**Stage 1 Concept DA & Demolition for 52 Phillip Street, Sydney (SSD-10464)
Public Exhibition**

Thank you for your correspondence via the Major Projects Portal on 13 April 2021, requesting Transport for NSW (TfNSW) to review and comment on the above.

Attachment A – Items to be addressed as part of the Applicant’s Response to Submissions

Figure 7: Crash map

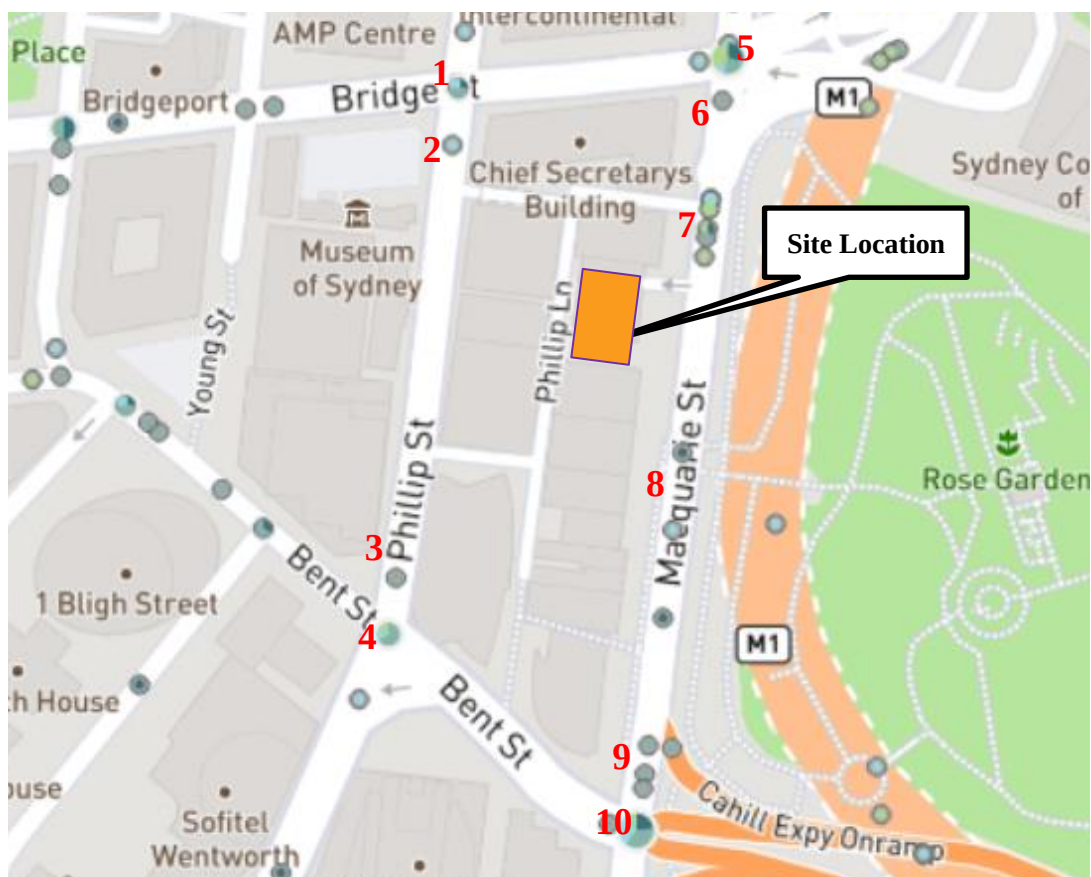
The site location identified in Figure 7 is not consistent with the other figure locations included in the Transport Impact Assessment.

It is requested that the applicant amends Figure 7 in consistent with other figure locations in the Transport Impact Assessment.

Figure 17 Strategic Cycleway Network Map

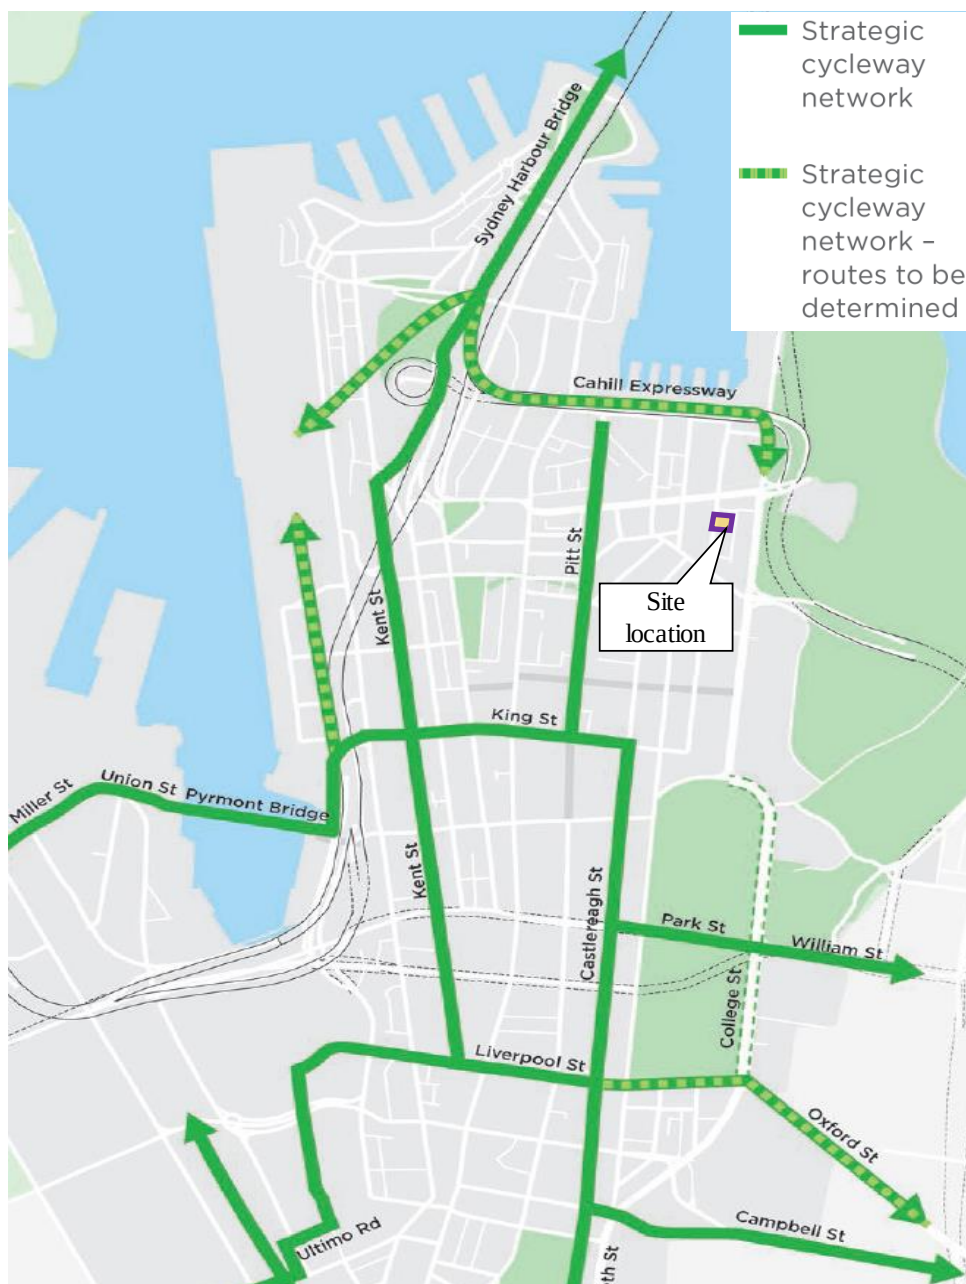
Section 6.2 of the Transport Impact Assessment states the following:

“The Sydney City Centre Access Strategy released in December 2013 identifies a fully integrated transport network for the city centre.”

It is requested that the applicant revises the Transport Impact Assessment to include that Sydney City Centre Access 2018 provides an update for how the Sydney City Centre Access Strategy has progressed.

Figure 18: Bicycle parking spaces

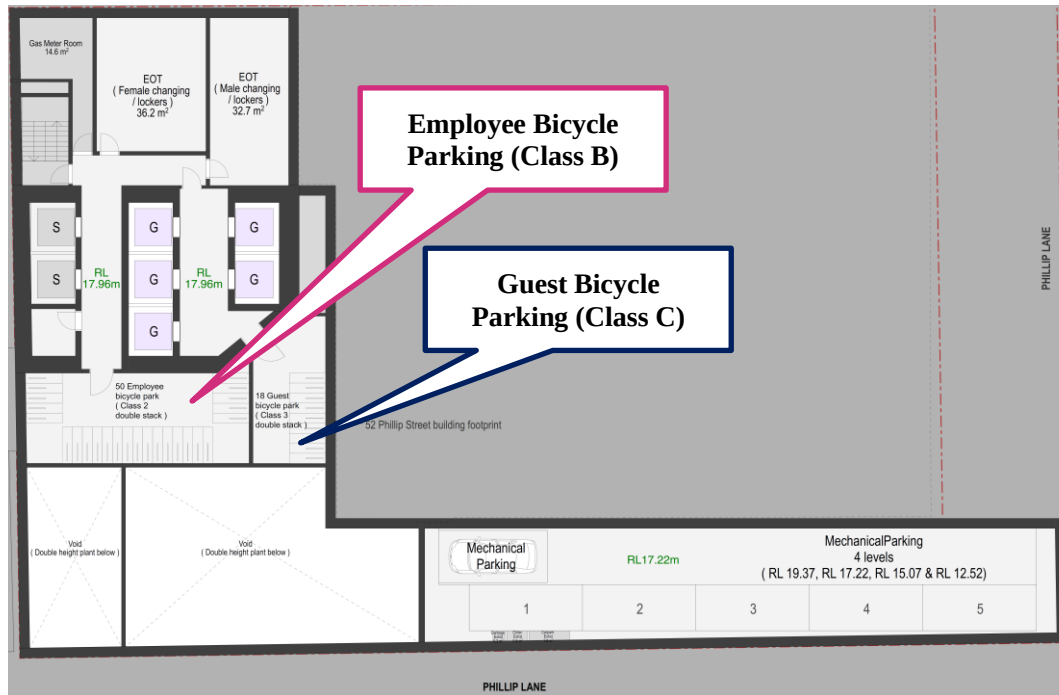
- Table 7 the Transport Impact Assessment shows 74 bicycle spaces are required for residents/employees and 21 bicycle spaces for visitors/customers/guests whereas the proceeding sentence says “The 74 secure bicycle spaces for residents, employees and visitors are provided in the basement level of the development;

- Specific requirements in relation to the mechanical car stacker for the reversing manoeuvres of vehicles accessing the basement needs to be provided;
- Confirm that the proposed mechanical car stacker would be compatible with motorcycles if the motorcycle parking spaces are to be located within basement levels;
- The terminology used when describing bicycle parking provisions for each user type and allocated location within the proposed development needs to be revised. In addition, the required bicycle parking provisions shown in Table 7 should be consistent with the allocations shown in Figure 18;

Figure 20: proposed drop-off and pick up area

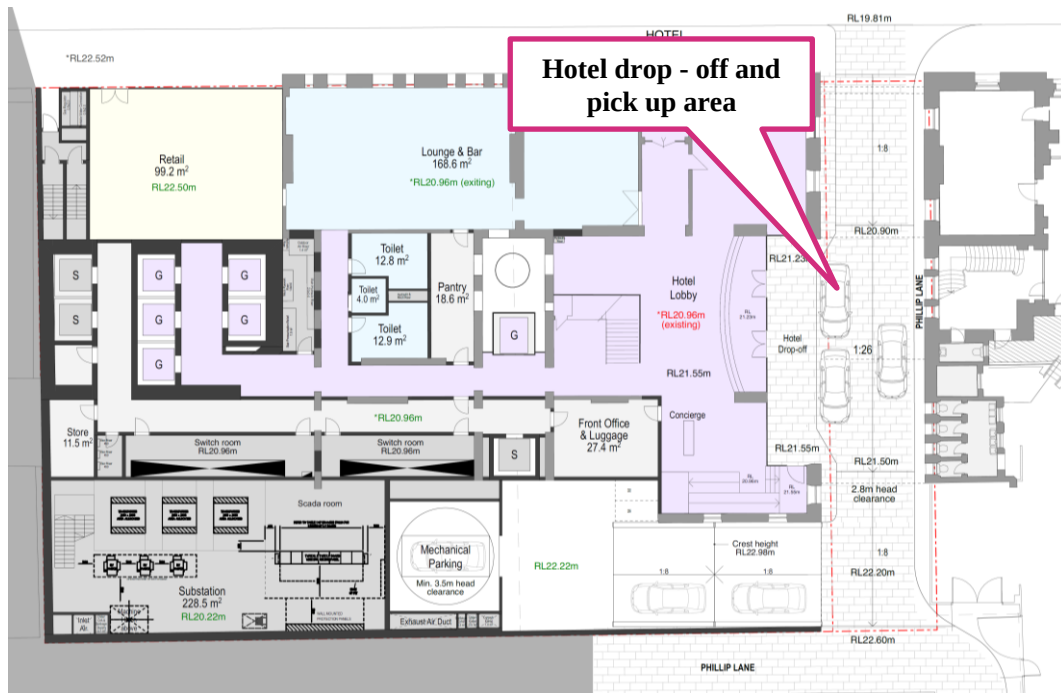
- Figure 20 the Transport Impact Assessment shows that two vehicles would be able to queue within the site whilst Appendix D provides a swept path diagram for passenger vehicles entering/exiting the site which shows only one queuing vehicle could be accommodated within the site.

"There is a Porte cochere proposed on Phillip Lane adjacent to the site (shown in Figure 20, with storage capacity for up to two vehicles if required.)"

- Confirm that the existing head clearance height of the Phillip Lane tunnel structure would permit Small Rigid Vehicles to undertake the illustrated left turn from Phillip Street; and
- Waiting area for the vehicles to be served by the lift needs to be marked based on results of the swept path analysis.

Figure 23: Proposed Construction Vehicle Routes

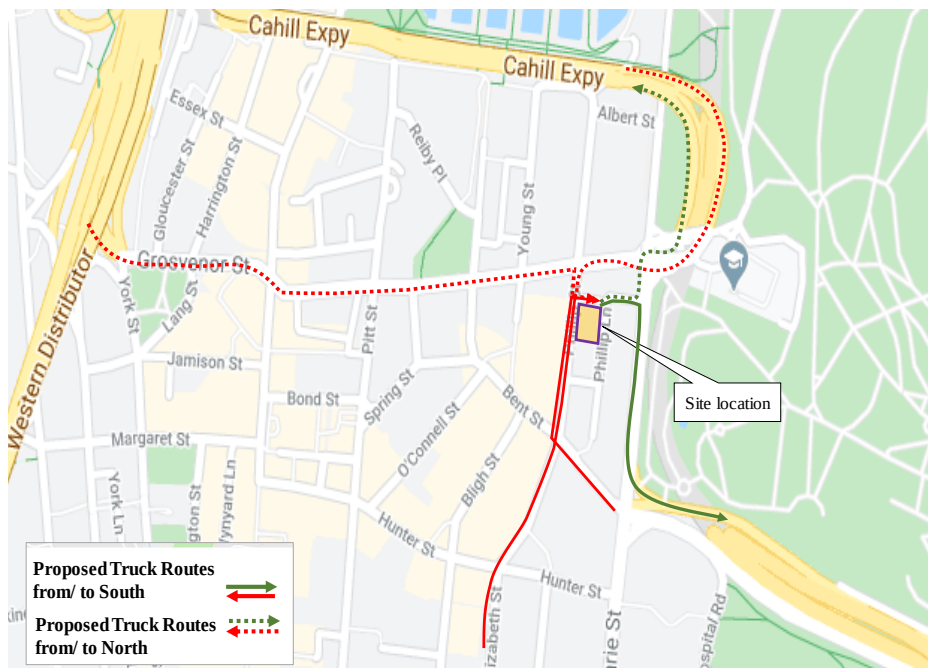
It is noted that the proposed construction vehicle routes are shown in Figure 23 of the Transport Impact Assessment. The following comments are made in relation to the proposed construction routes:

- Construction vehicle access via turning right from Phillip Street into Phillip Lane and egress via turning right from Phillip Lane into Macquarie Street would not be supported as these movements would have the potential to impact on the existing traffic and public transport operation; and
- The existing height clearance of the Phillip Lane tunnel structure is 2.8m. This would have the potential to limit construction vehicles to access the site from Phillip Street.
